Response to groundwater independent peer review

22 February 2021

Our ref: 754-SYDGE206418-3-AP-Rev1

CGO Underground Development EIS - Addendum 1 of the hydrogeological assessment

Figure 29: Inflow / outflow at model boundaries and Lake Cowal nodes for the Lake Cowal dry case

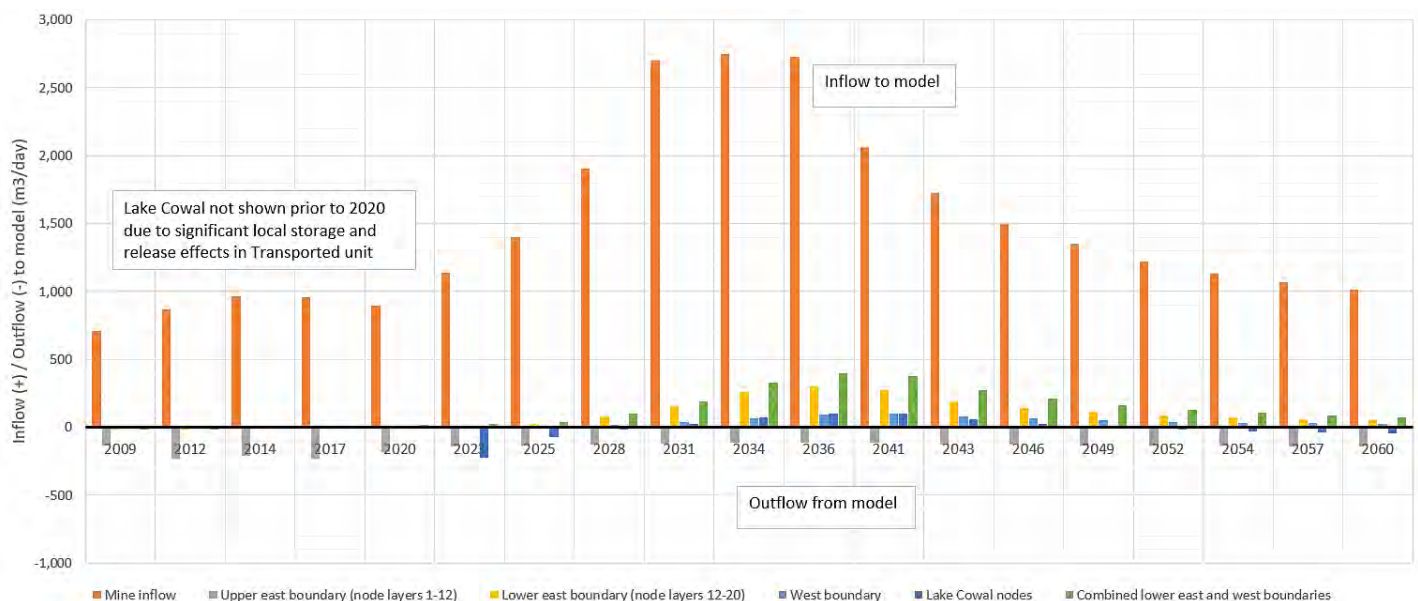
3. Provide more detail on the components of the water balance, notably components of discharge via dewatering bores, and via seepage faces at the pit walls and floor, and via horizontal drains, and leakage from the lake that is captured by the mine, including differences during lake full and empty periods.

Figure 5 and Figure 6 present inflows into the model from the fixed head western and eastern boundaries, and from the Lake Cowal time varying fixed head nodes, excluding rainfall recharge. These figures show the dry Lake Cowal and full Lake Cowal cases respectively. The results divide the eastern boundary into an upper and lower level. This was done to separate localised outflow at the top of the eastern model boundary which occurs due to the interaction of the Lake Cowal fixed head nodes and the eastern boundary fixed head nodes. This flow to the east from the eastern part of Lake Cowal has a negligible impact on inflows to the mine site. This can be seen more clearly in Figure 7, which shows the typical groundwater head contours along a west to east section through the mine in 2024.

Figure 5 shows a small amount of flow into the model from the Lake Cowal nodes for a dry Lake Cowal case. This is a result of a fixed head boundary condition of 201.5 mAHD being applied to these nodes for the dry Lake Cowal case. The rate of inflow to the model from the Lake Cowal nodes is under 5% of the total inflow to the mine and is not considered to affect the predicted inflow to the mine.
